This is to certify that Knight Thomas C. & North R Builder
has permission to Build new 365 sq ft deck attached to single family residence
AT 88 Shepherd Ln 351 A025001

Permit No: 04-0898	Issue Date: JUL 30 2004	CBL: 351 A025001
-----------------------	----------------------------	---------------------

Proposed Project Description:
Build new 365 sq ft deck attached to single family residence

CBL: 351-A-25 Building Permit #: 04-0898

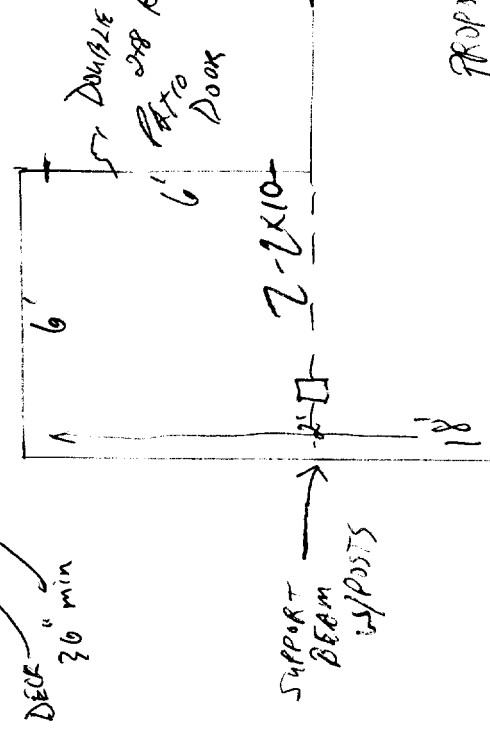
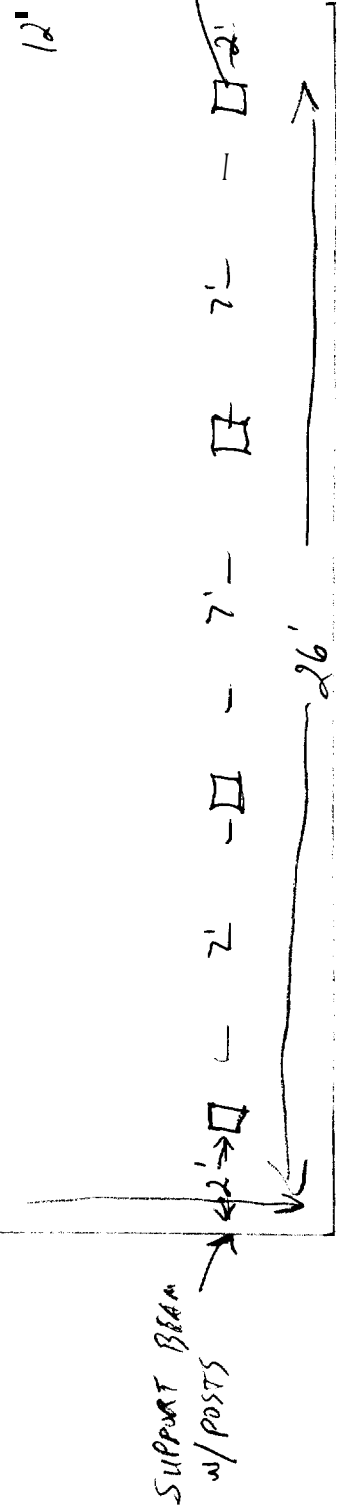
Comment Date	Comment				
<input type="text"/> 07/28/2004	<input type="text"/> Need size and depth of tubes, stair dimensions, ledger size and bolts, guardrail details, new openings in house to deck. <i>Builder is out of state & will call next week.</i>				
Name	<input type="text"/> imm	Follow Up Date	<input type="text"/>	Completed	<input type="checkbox"/>

Comment Date	Comment				
<input type="text" value="07/30/2004"/>	<input type="text" value="ok to issue - contractor come in and made notes on plans."/>				
	Name <input type="text" value="tmm"/>	Follow Up Date <input type="text"/>	Completed <input type="checkbox"/>		
<input type="text" value="07/28/2004"/>	<input type="text" value="Need size and depth of tubes, stair dimensions, ledger size and bolts, guardrail details, new openings in house to deck. Spoke w/builder - they are out of state and will call the end of the week."/>				
	Name <input type="text" value="tmm"/>	Follow Up Date <input type="text"/>	Completed <input type="checkbox"/>
